From: Amanda Scholes on behalf of Planning.Responses
Sent: 19 August 2019 09:00
To: Planning Scanning
Subject: FW: AB/68/19/HH & AB/69/19/L

AB/68/19/HH & AB/69/19/L

Avola House is a late 18th Century Grade II Listed Building which is located within the centre of Arundel. It is a four-storey house on the Northern side of Tarrant Street, at the apex of Bakers Arms Hill. Whilst it appears to be a detached building, it is essentially a semi-detached house, since a separate property is attached to its northern elevation.

EXISTING WEST ELEVATION & SECTION A-A
DATE. June 2019
SCALE. 1:100 @ A3
JOB No. 1070
DRWG No. 107 Rev.

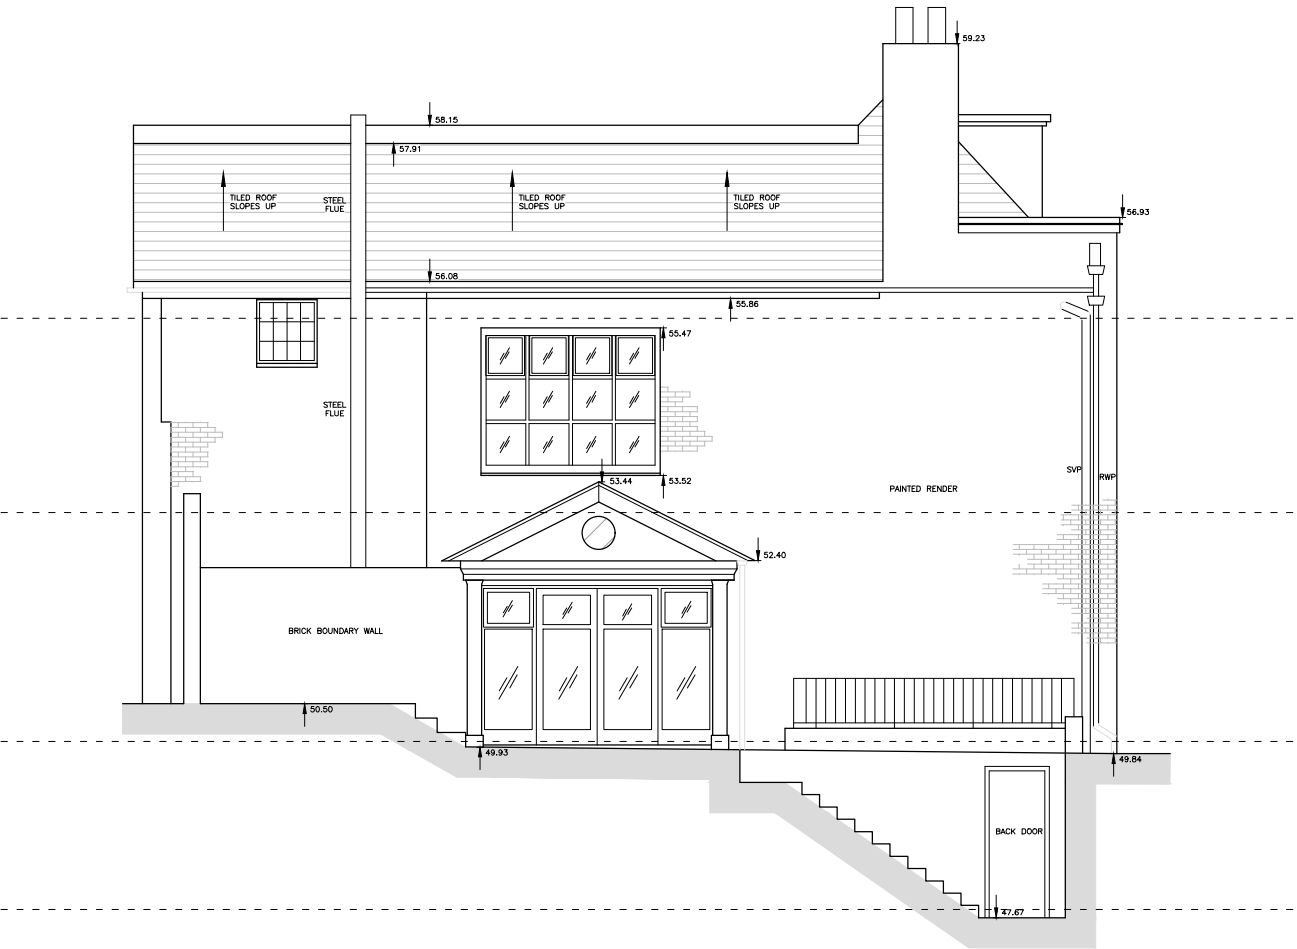
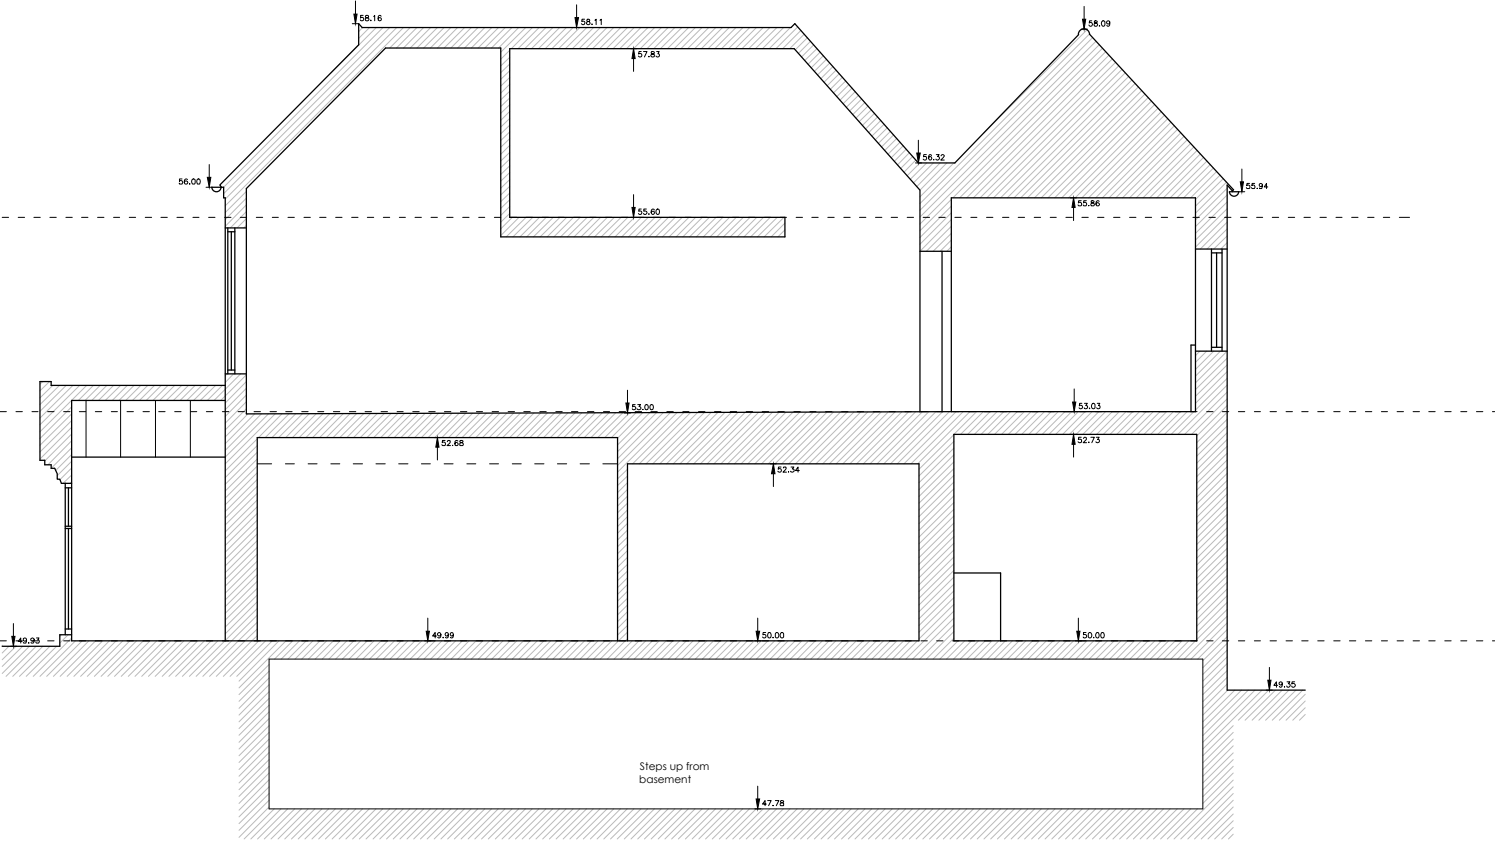
The replacement of the modern feature window to the West elevation at First Floor level will result in a much more appropriate fenestration detail and would enhance the elevations. Such a move will enhance the elevation, and therefore the building.

Work to expose the original brickwork on western elevation will allow an inappropriate material to be removed, the bricks to 'breathe' and the original appearance to be restored. However, there is potential for the works to damage the bricks and therefore the elevation. Works should be carefully carried out by any skilled contractor. You may wish to ask for a method statement in order to ensure that no harm is caused. Likewise, details of the repointing should be provided in order to ensure that the new work replicated the existing.

PROPOSED SECOND FLOOR

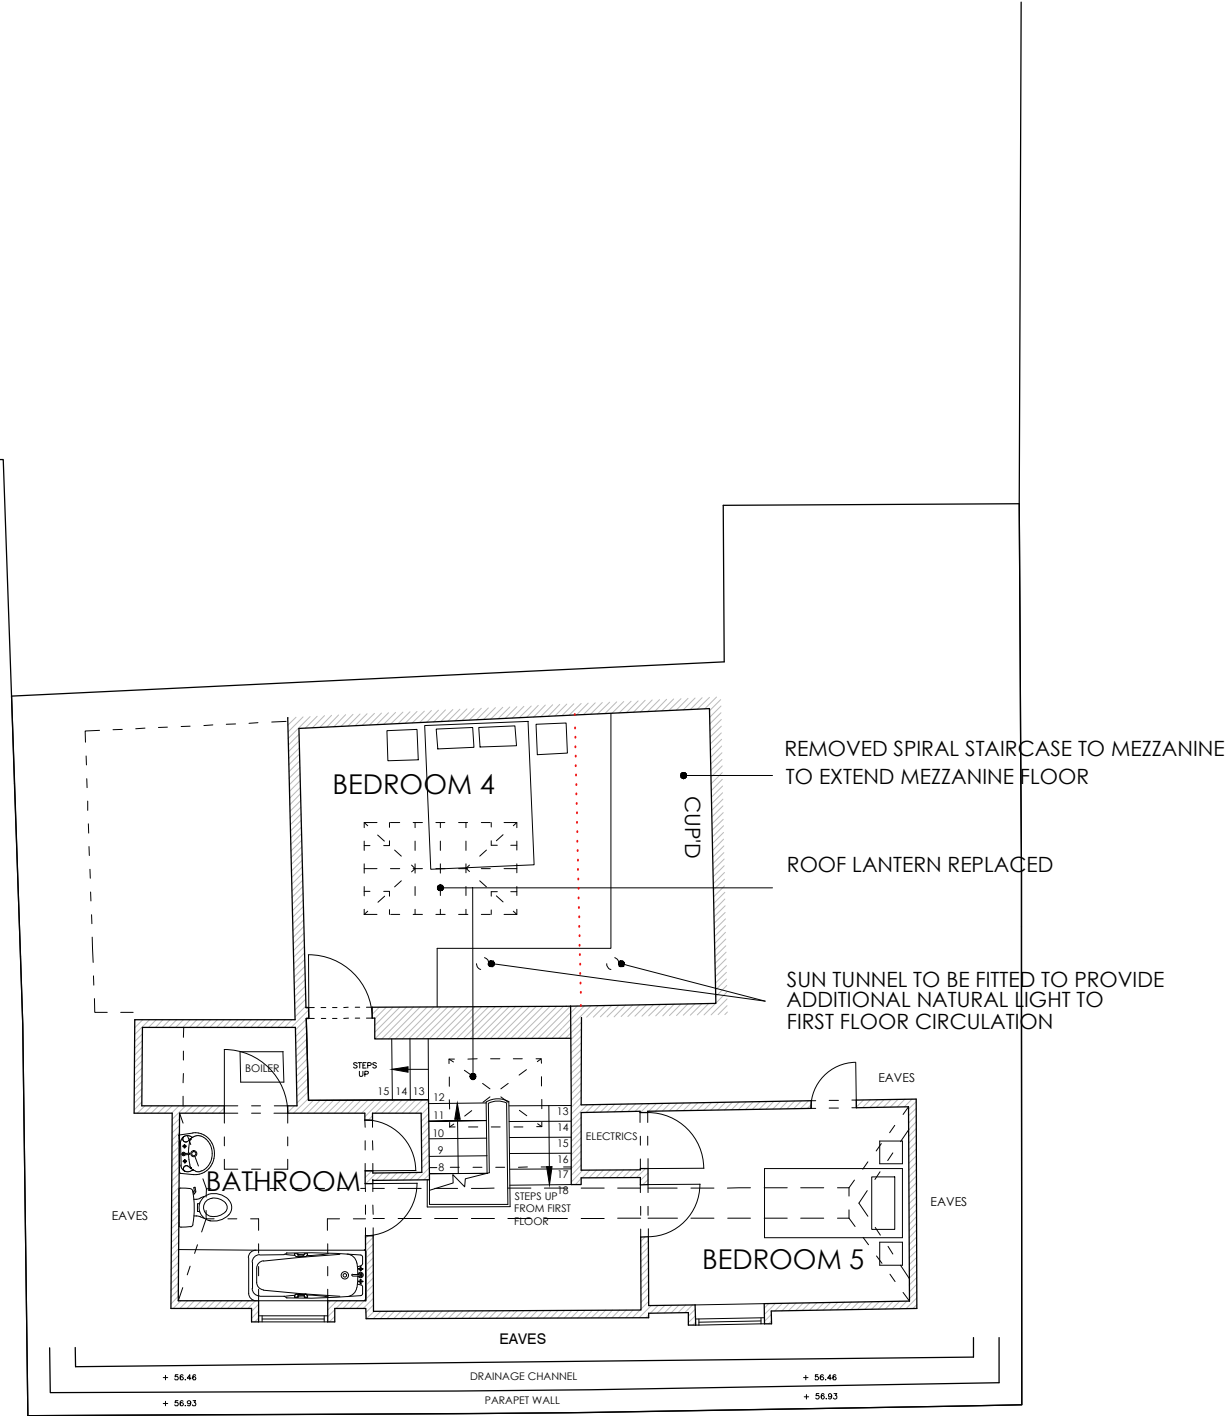
The removal of the spiral staircase and associated works in order to create a bedroom and two bathrooms will remove modern works/fabric which are not considered appropriate for the significance of the building. It will also introduce spaces which are more appropriate for the building.

EXISTING EXTERIOR STAIR SECTION
DATE. June 2019
SCALE. 1:50 @ A3
JOB No. 1070
DRWG No. 118 Rev.

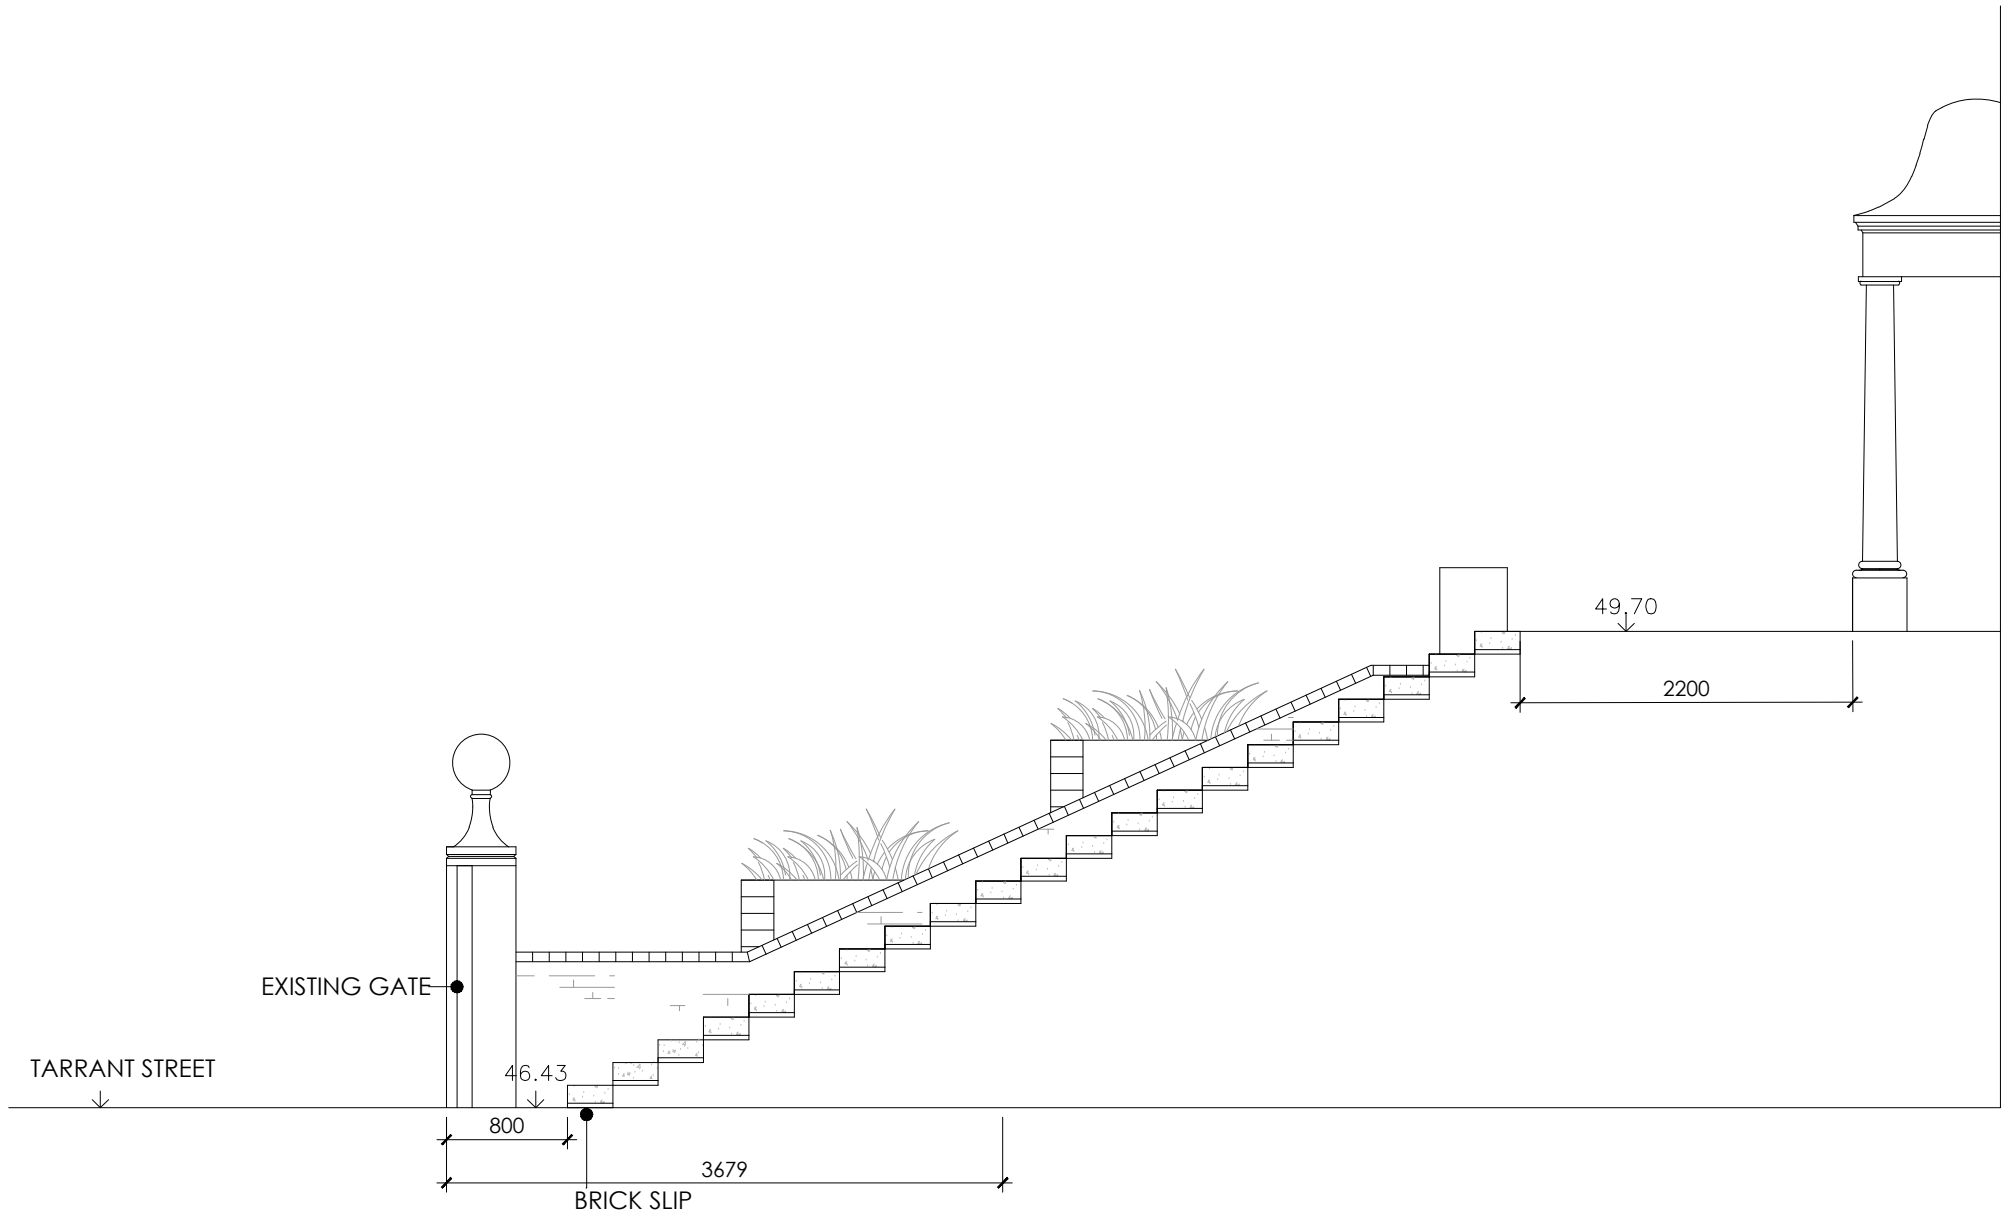
The reconstruction of the damaged external steps and the creation of a refuge at street level to allow for safe access from Tarrant Street seems to be an acceptable approach. However, I note from the listing description that some of the steps include a local stone (Bognor Rock). This material should be incorporated within the design in a similar way/appearance. Such an approach should be confirmed.
